Document 3.1 – ES Volume 2

Appendix 3.5: Response to S42 consultation 2018

Wheelabrator Kemsley (K3 Generating Station) and Wheelabrator Kemsley North
(WKN) Waste to Energy Facility DCO

September 2019 -Submission Version

Figure 2: K3 Works Plan

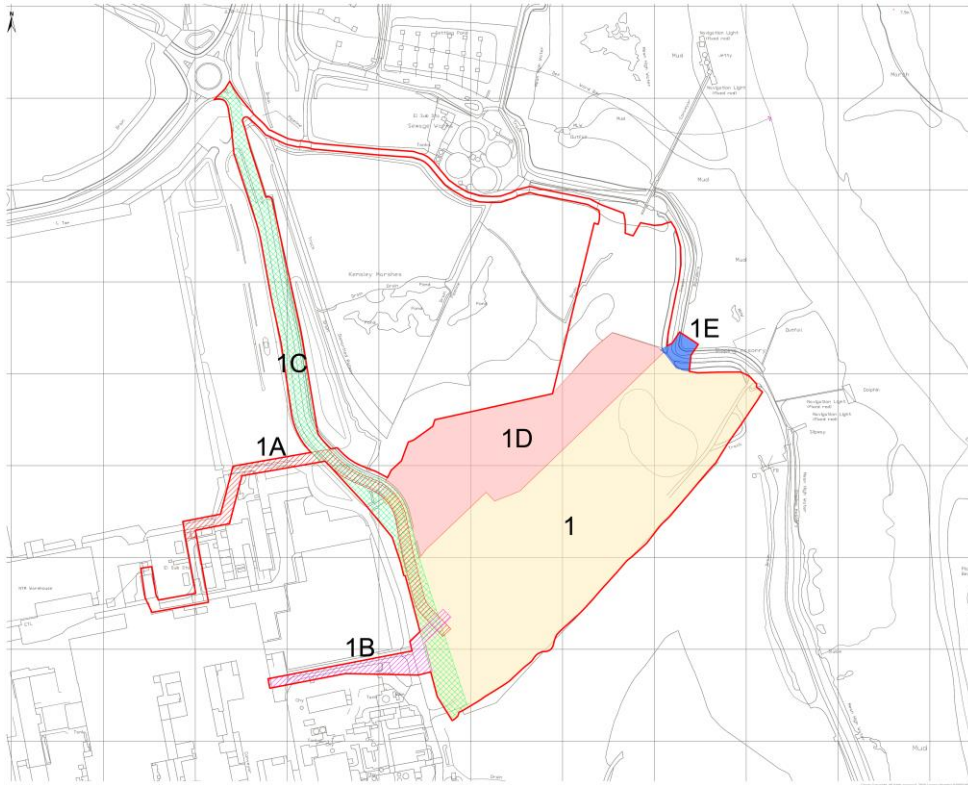
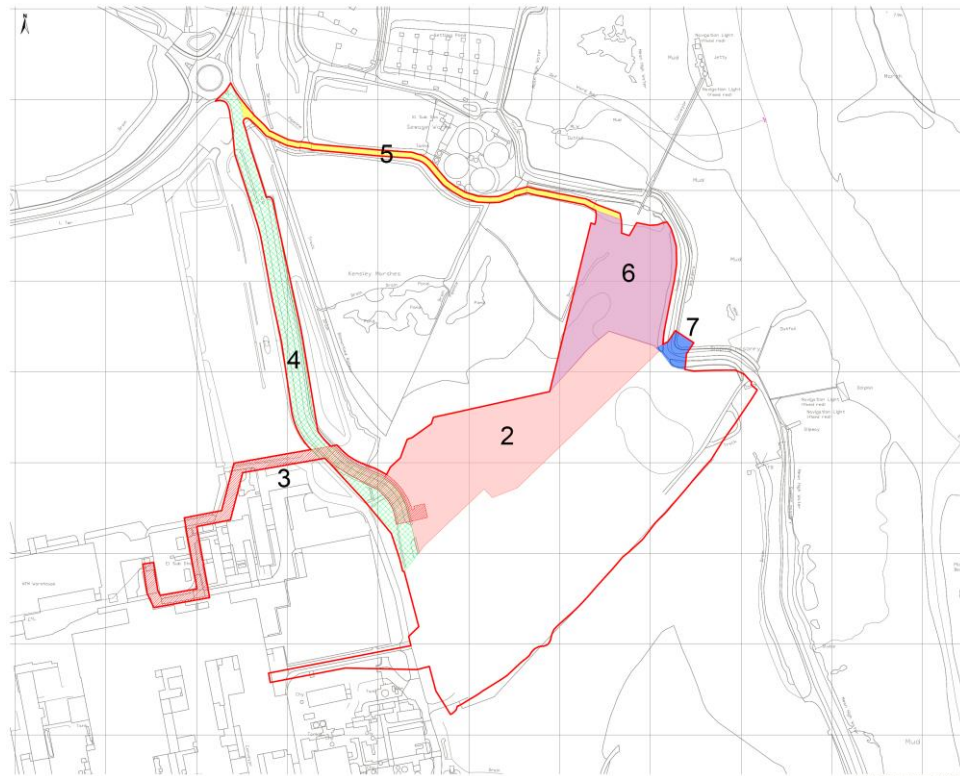
'S42 Site Location Plan' within this Section 42 consultation appears to support the conclusion of the Scoping Opinion consultation response with the K3 site, (Works Area 1 as illustrated on 'S42 Works Plan'), shown as entirely above MHWS.

Again, 'S42 Site Location Plan' within this Section 42 consultation request appears to support this conclusion with relation to the WKN site, (Works Area 2 as illustrated on 'S42 Works Plan'), shown as entirely above MHWS. However, 'Appendix 10.2 Drainage Design Philosophy', submitted with the S42 documents, states at paragraph 2.7 that 'Surface water will be discharged offsite from the attenuation pond into the Swale Estuary to the east of the WKN Site' and that 'Surface water will therefore be discharge un-attenuated via a new headwall adjacent to the existing headwall serving the neighbouring site.'

'S42 Works Plan' within this Section 42 consultation identifies Work Area 7, which appears to correspond with the outfall licence area for L/2017/00482/1, and, from the plans submitted, is the only area of works which appears to fall below MHWS and therefore within the MMO's remit.

However, there appears to be no further reference to this Work Area within the submitted S42 documents.

Clarification is required as to whether works in relation to the proposed outfall and new headwall for WKN will be carried out under marine licence (i.e. variation to L/2017/00482/1), under a new marine licence application, or via deemed marine licence incorporated into the current DCO application.

Any works associated with Works Area 7 and falling below MHWS, (i.e. proposed outfall and new headwall) must be fully assessed in terms of potential impacts on the designated features of the Swale Estuary.

A new surface water outfall will be constructed adjacent to the existing K3 outfall between the Mean High Water and Mean Low Water intertidal area (Work No.7, see Chapter 2).

A variation to the K3 MMO licence (Marine Licence L/2017/00482/1) has been approved to discharge clean water from the WKN Proposed Development into the Swale Estuary.
